Our reference: P-900143-B4C9  
Contact: Nick McMaster  
Telephone: (02) 4732 8578

**Council Response to Environmental Impact Statement – SSD-70817958 – DHL Logistics Facility Badgerys Creek North at 1953–2109 Elizabeth Drive, Badgerys Creek, NSW, 2555**

Council staff has reviewed the information referred for comment on 16 April 2025 and provides the following advice for the Department's consideration.

TITLE	GF PLAN - STAGE 2
DATE	08/10/2024
SCALE	1:750 @ A1 1:1500 @ A3
PROJECT NO.	21254
DWG NO.	DA101
REVISION	12

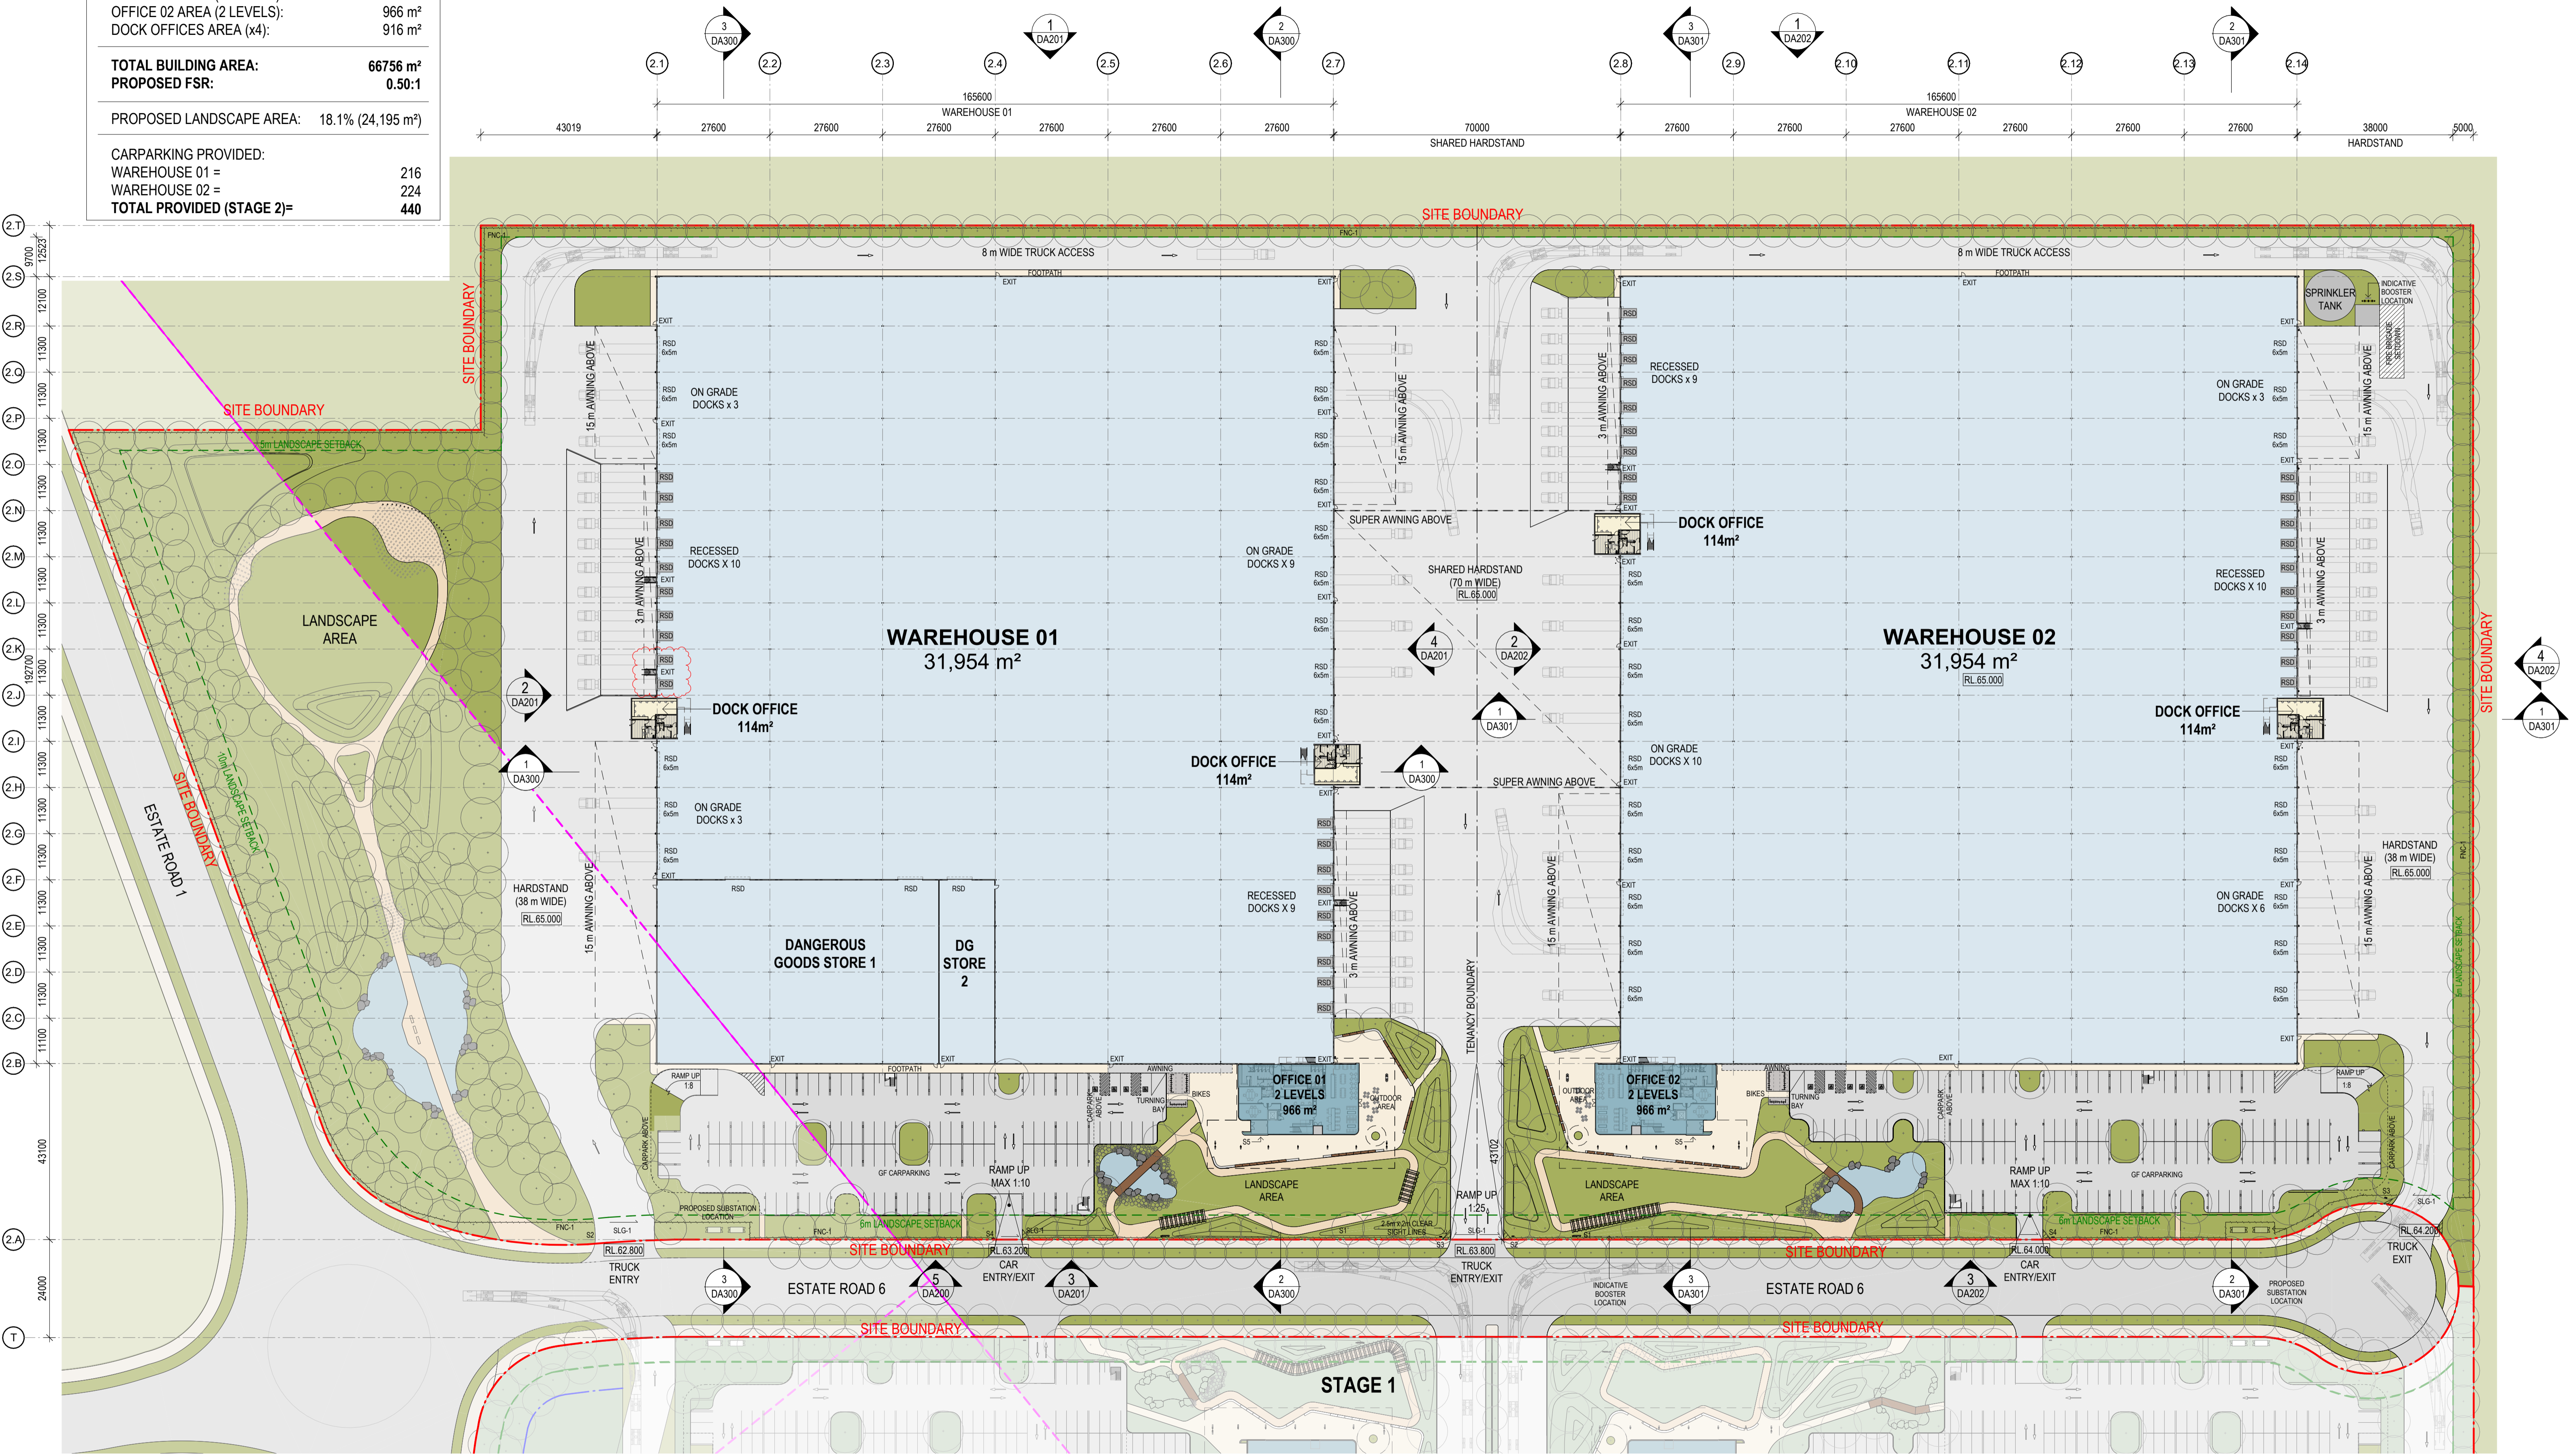
- a) Clarification is required regarding compliance of the westernmost proposed truck entry point, with respect to its proximity to the adjacent intersection. No clear dimensions are given for assessment of potential impacts on the intersection and risk of rear end collision in instances where trucks slow/stop to enter the driveway immediately after exiting the proposed roundabout at the intersection. Further detail is requested.
- b) The architectural plans are not of sufficient detail (dimensions not provided for assessment purposes) to assess whether compliance

with AS 2890.2 has been demonstrated regarding all proposed truck entry/exit driveways.

- e) Any internal driveway access gates/boom-gates/etc. must be positioned internally such that a full vehicle length (of the largest vehicle designated to use the corresponding entrance) can be accommodated wholly within the site and not queue on the public roadway. It is not clear from the application whether this has been achieved.

TITLE	CARPARKING LAYOUT - WH 02		
DATE	30/09/2024	SCALE	1:250 @ A1 1:500 @ A3
PROJECT NO.	21254	DWG NO.	DA103
REVISION			7

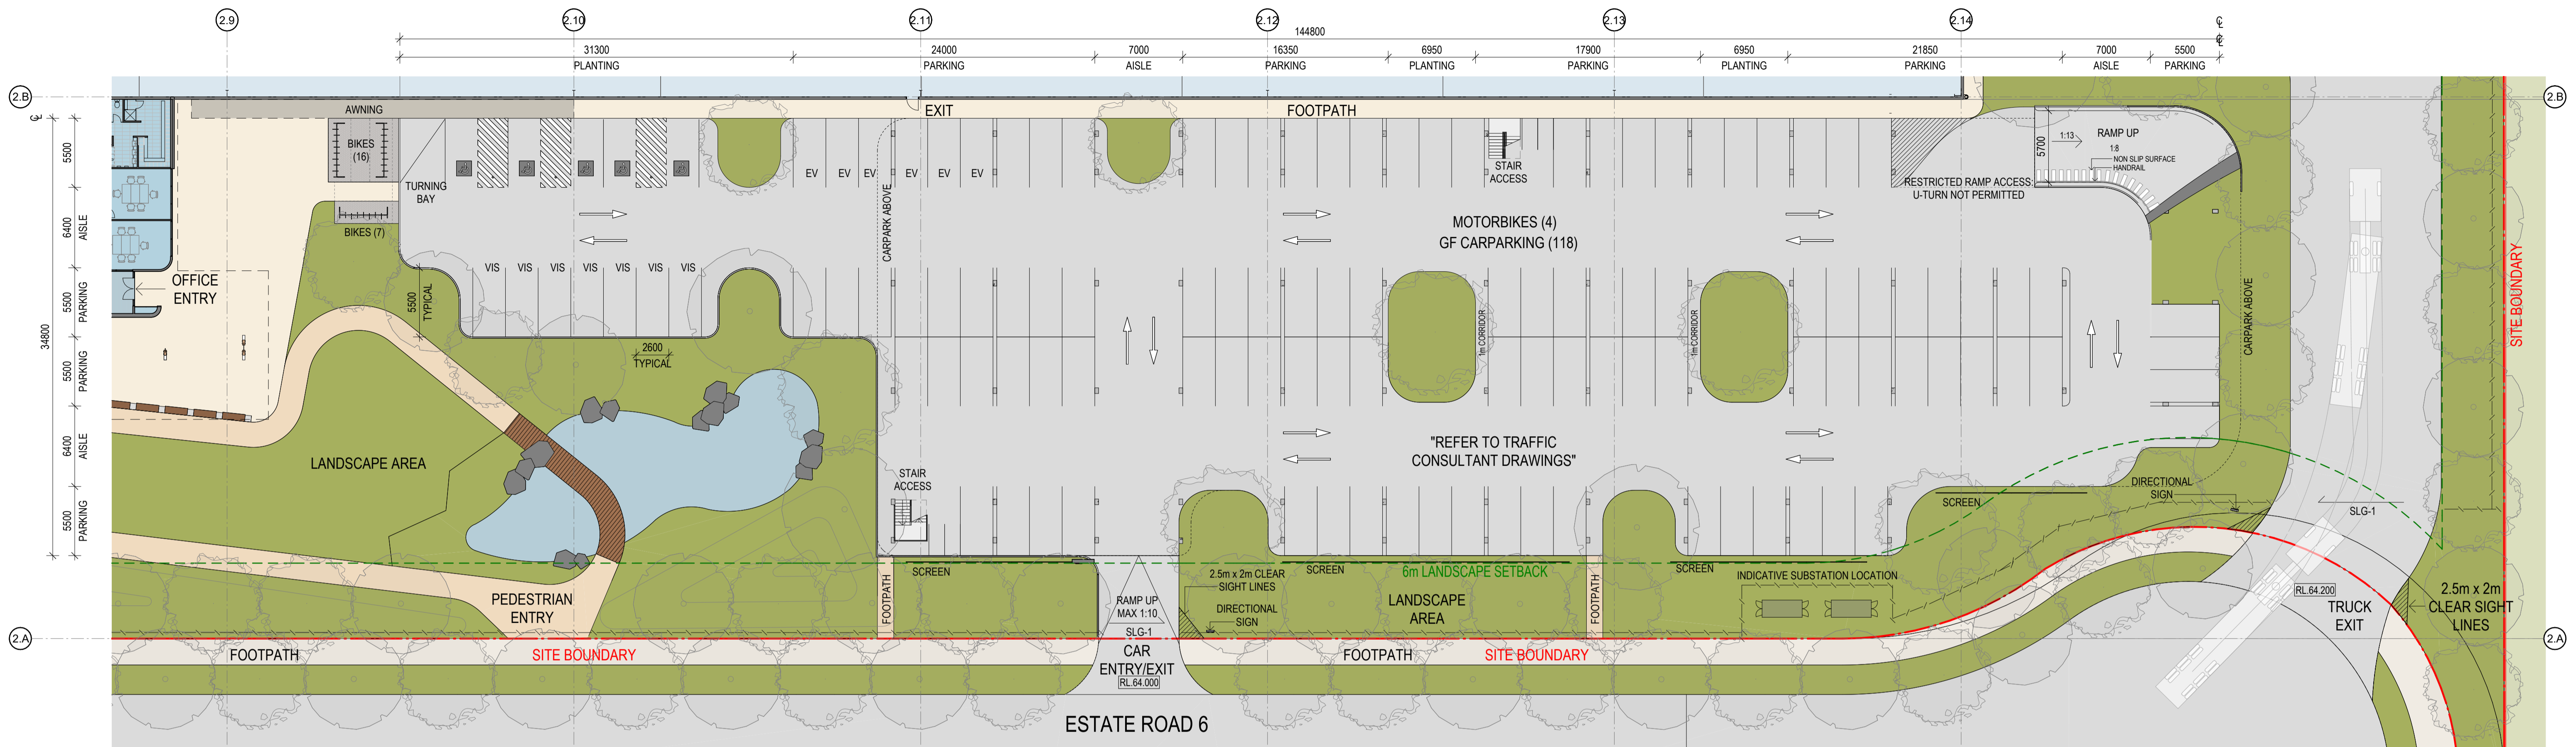
- d) The car parking areas do not provide tree planting at intervals of every five car parking spaces, as required by clause 2.4.4 – PO6 of the Aerotropolis DCP. The design of the mezzanine car park does not permit tree planting as required by the DCP. The proposed landscaped cut-outs are insufficient to meet the Performance Outcomes of the DCP, and this design does not address urban heat.
- e) In addition, clause 2.7 of the DCP (PO8) refers to parking at grade “*or if provided above the ground floor level within a building*”. The proposed upper-level parking is not integrated into the building. This, coupled with the lack of tree planting, is a poor urban design and visual outcome.

- c) The architectural plans are not of sufficient detail (dimensions not provided for assessment purposes) to assess whether compliance with AS 2890.1 has been demonstrated regarding car parking areas.
